Project #: 1005251

Project Name: PARIS ADDITION

**CITY OF ALBUQUERQUE  
PLANNING DEPARTMENT  
February 19, 2014  
DRB Comments**

**RE: Lot A-1, Block 20 Paris Addition**

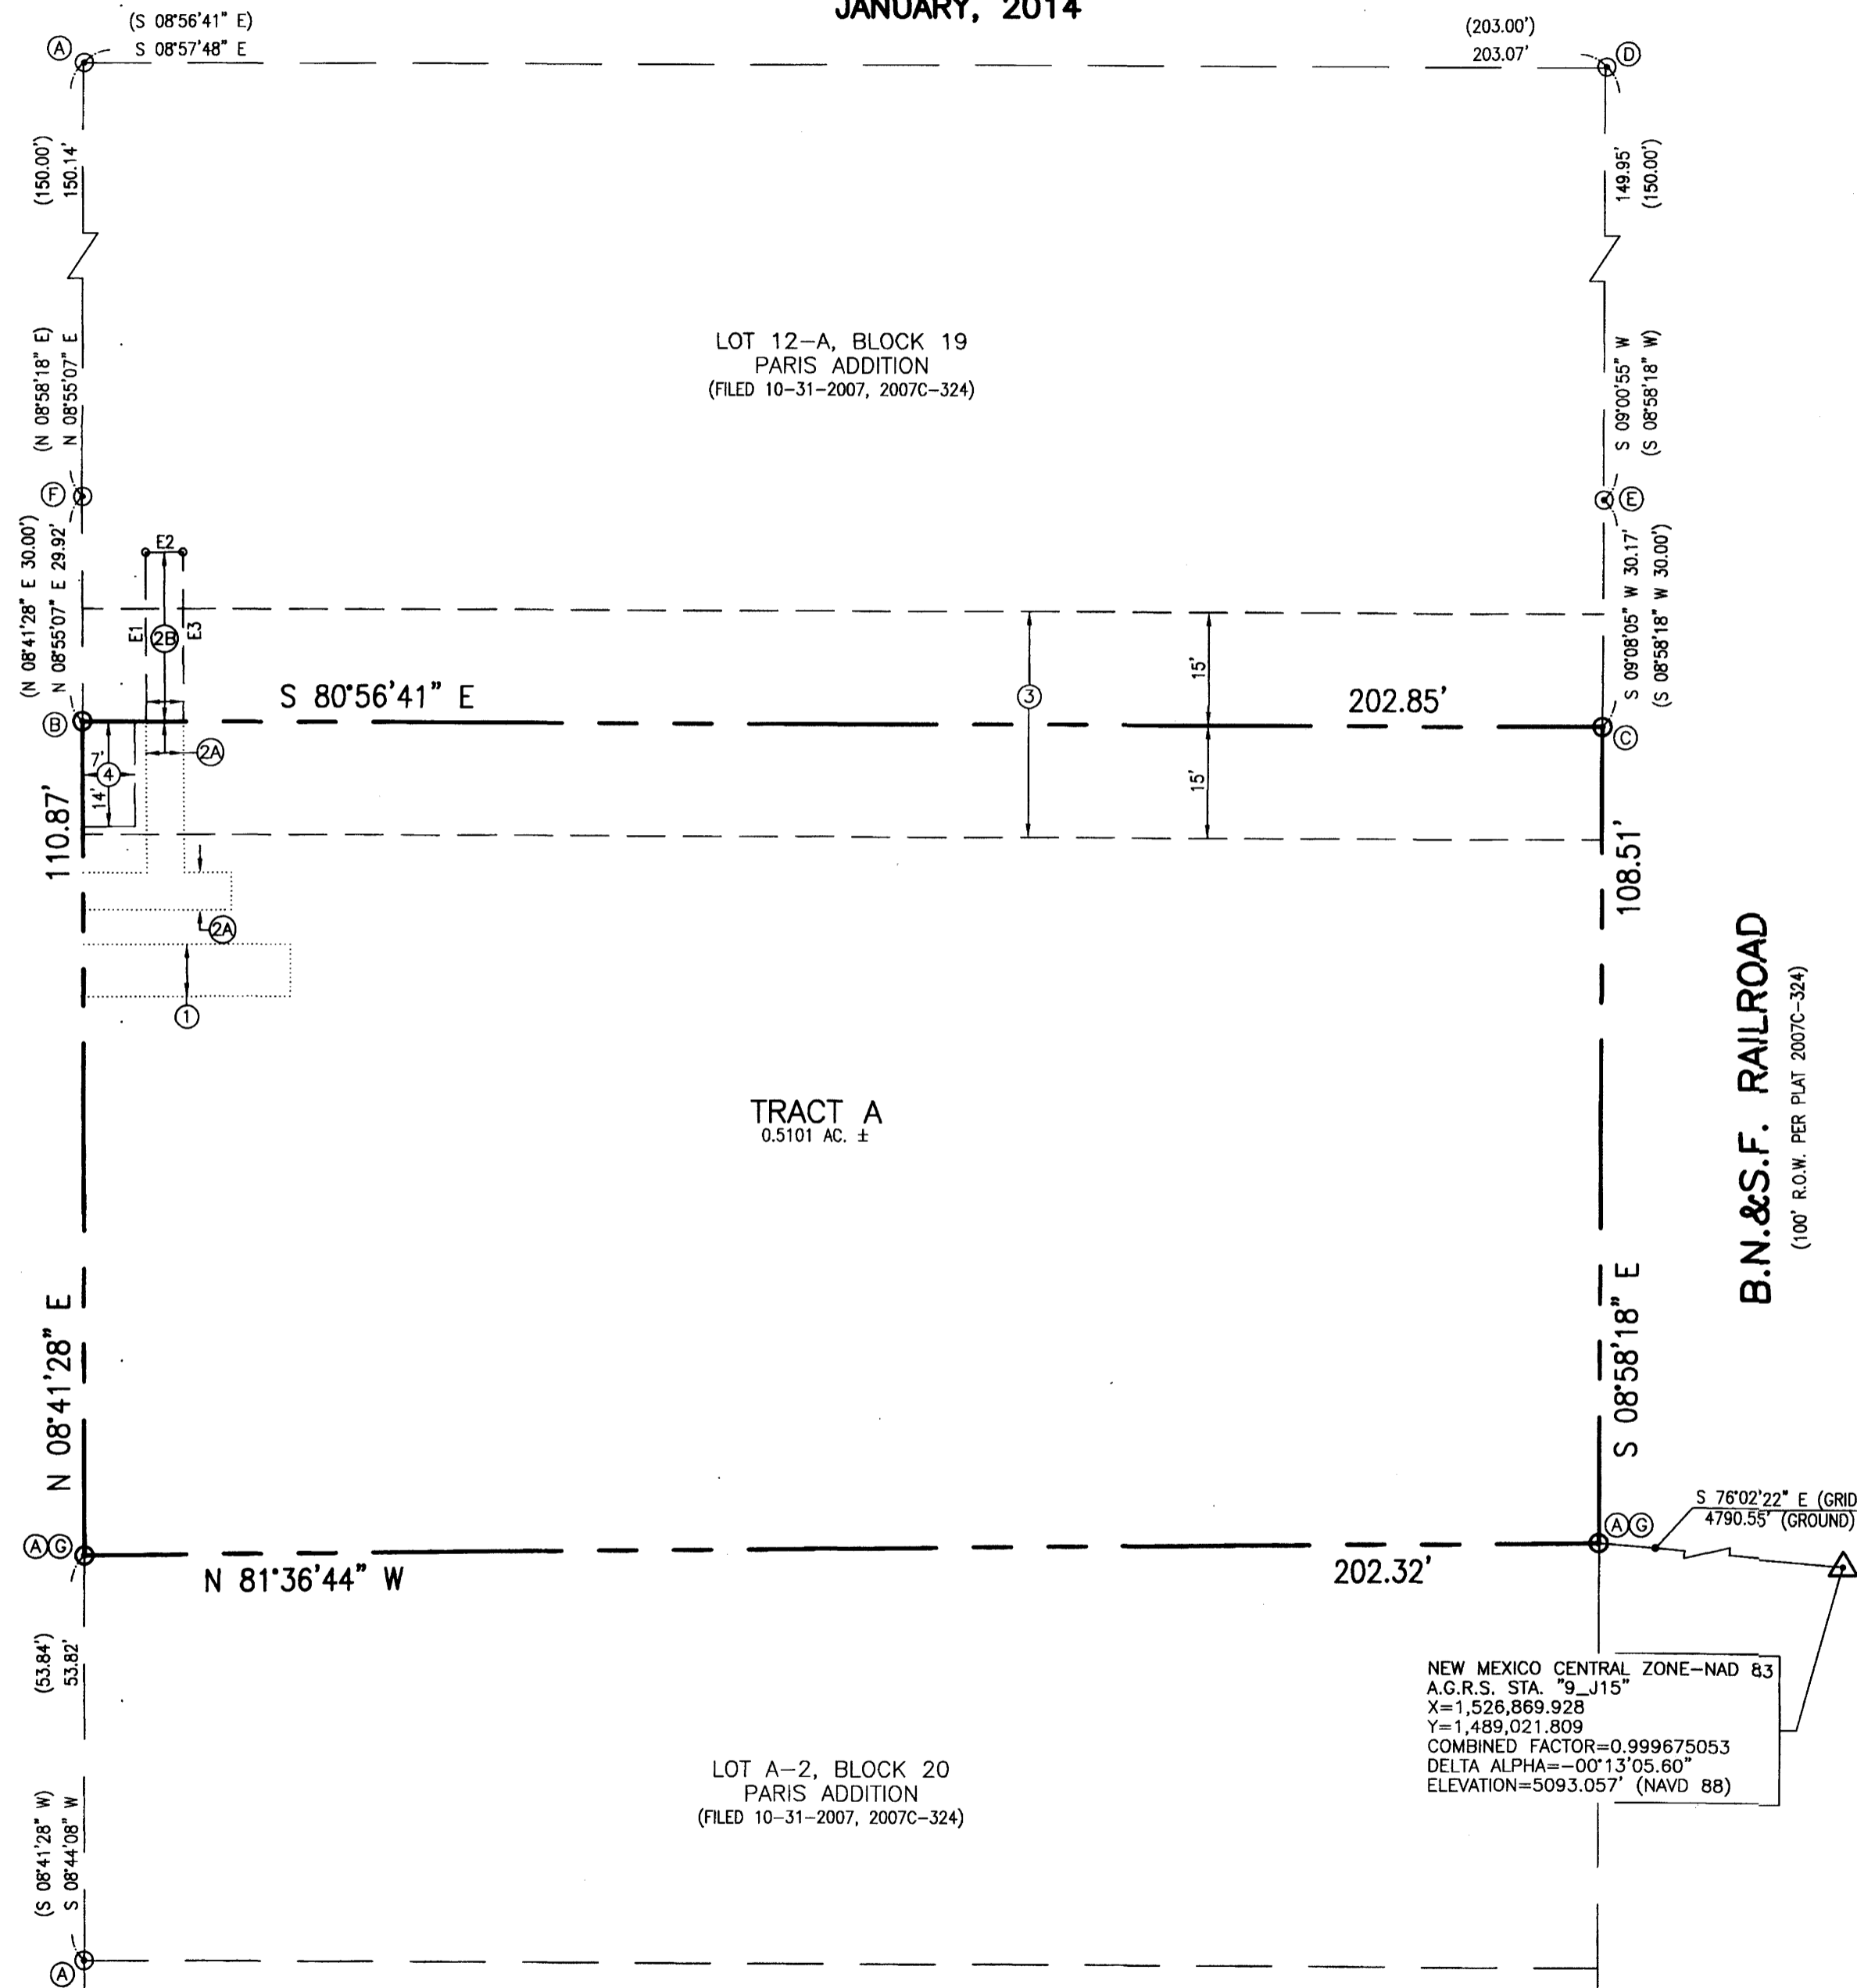
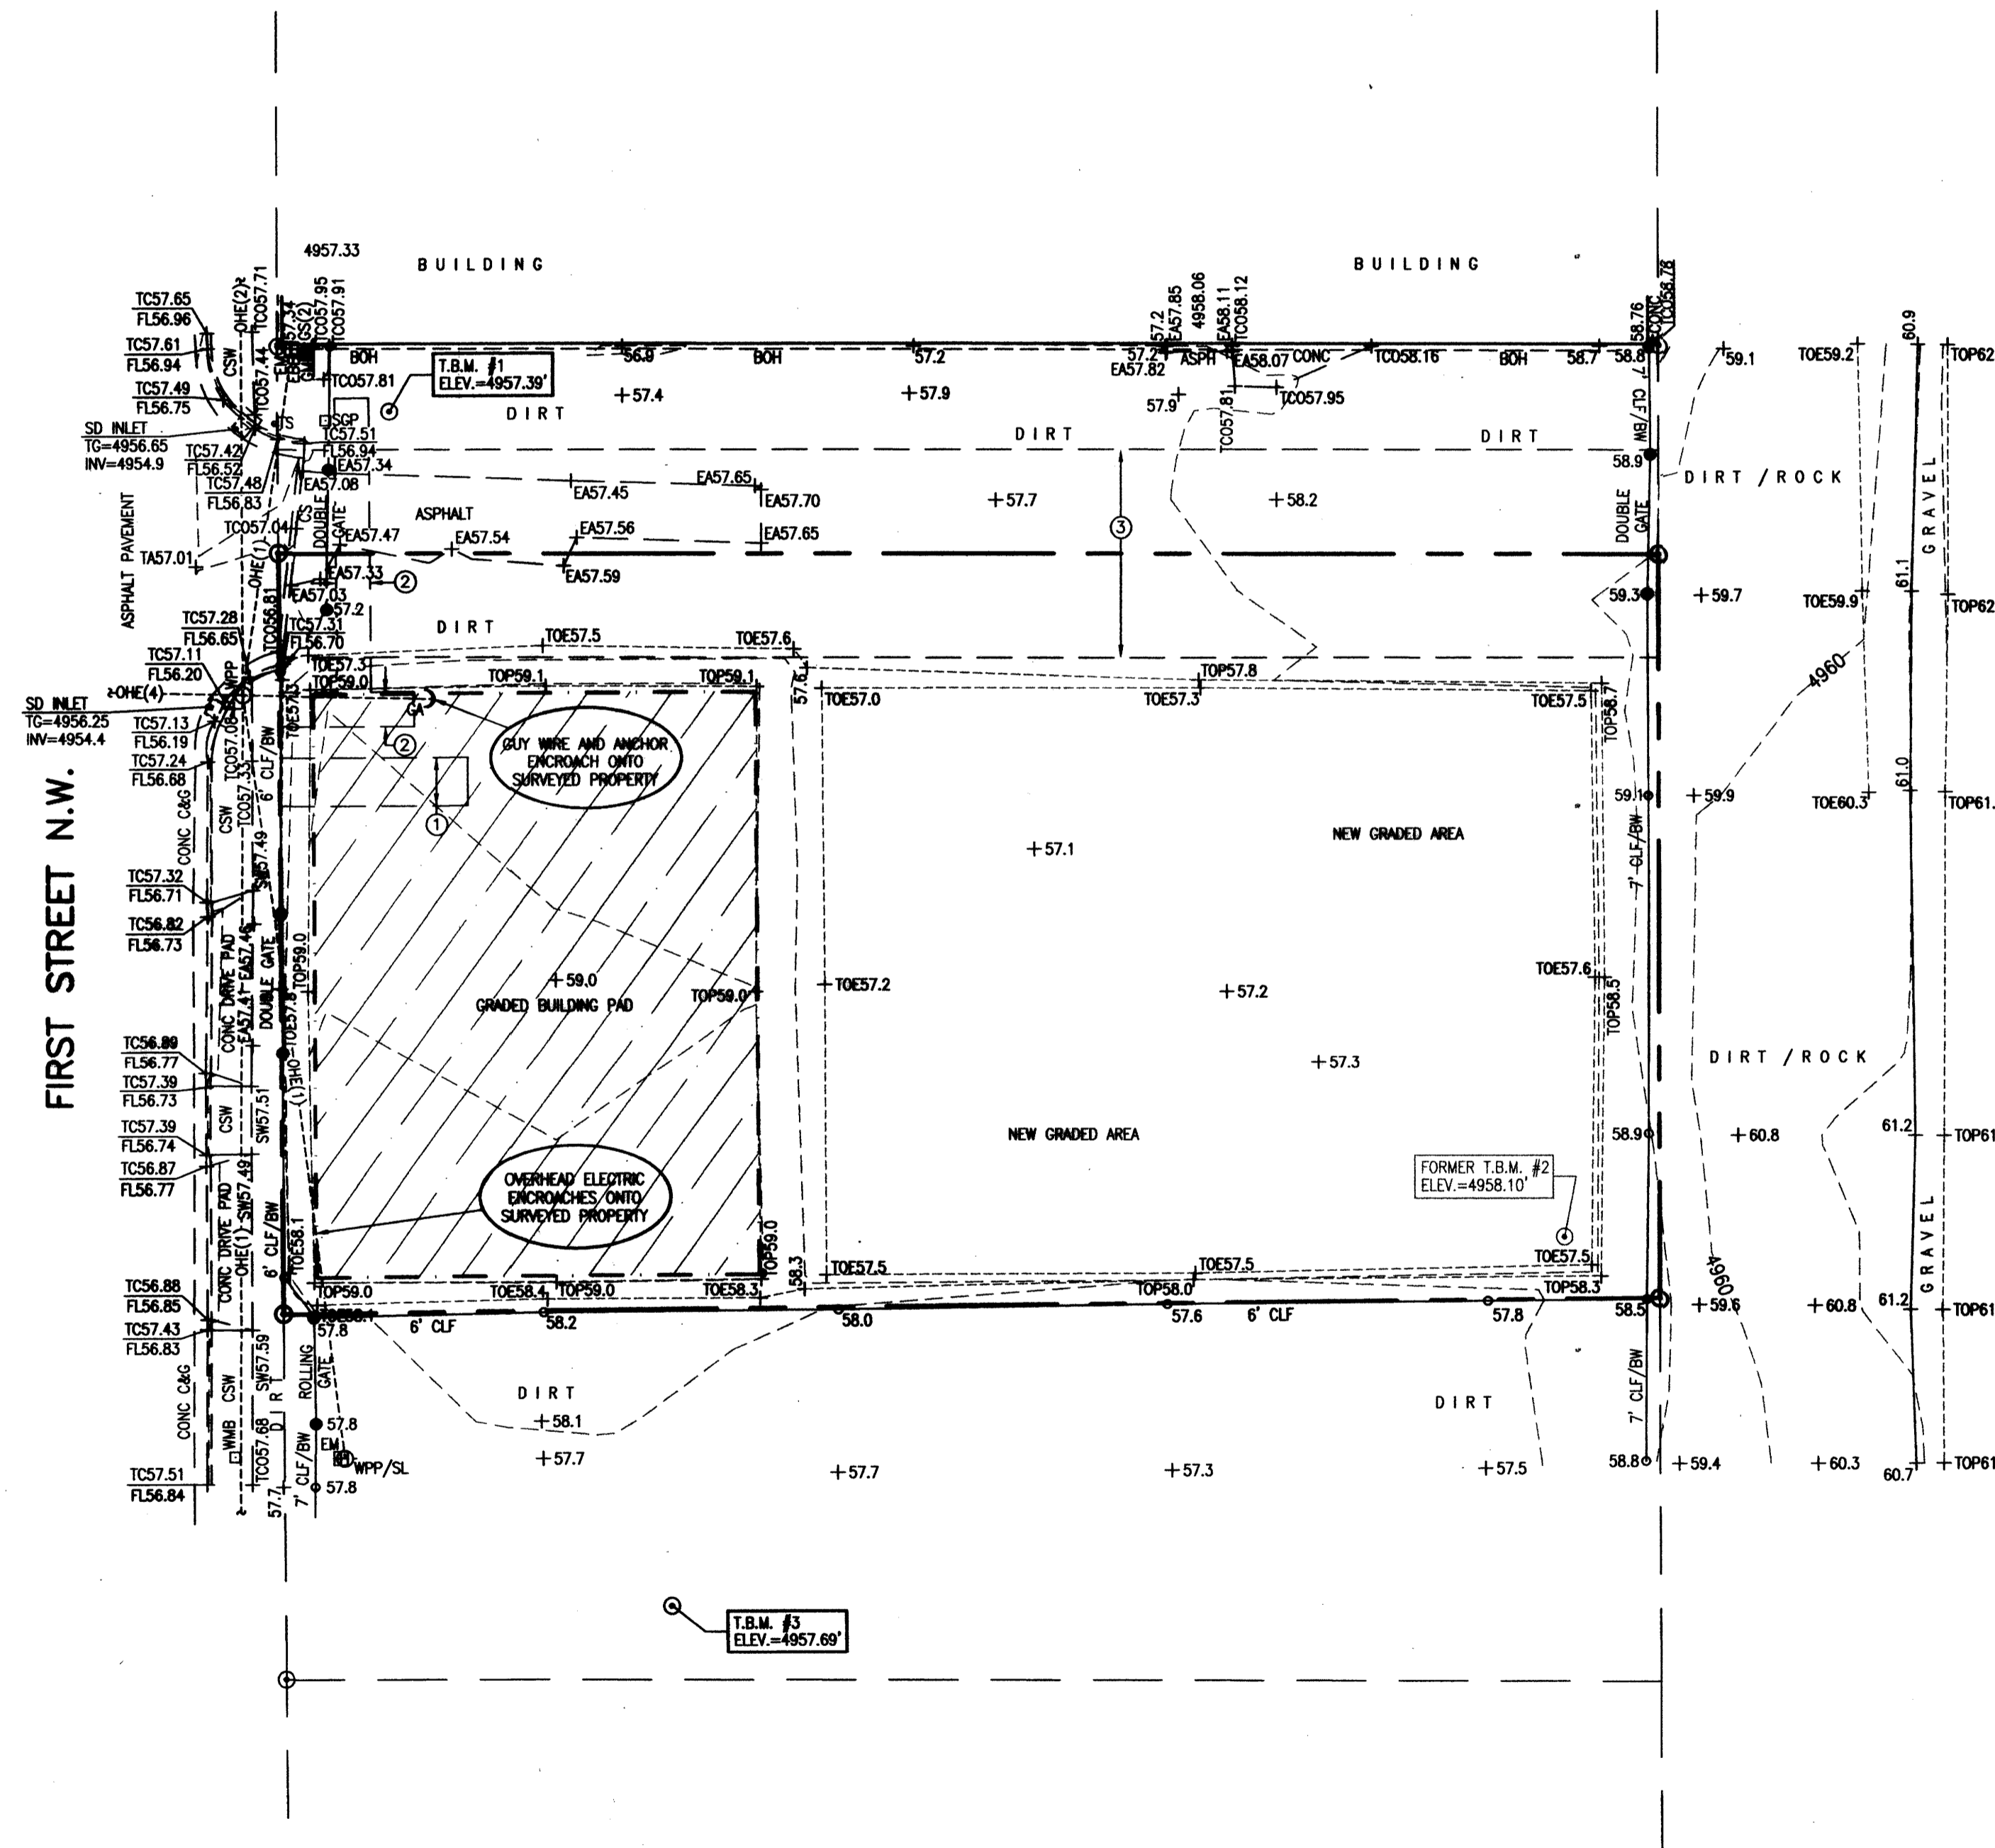
“Overhead Electric” Line serving property to the south of this site needs to be relocated or an easement needs to be provided.
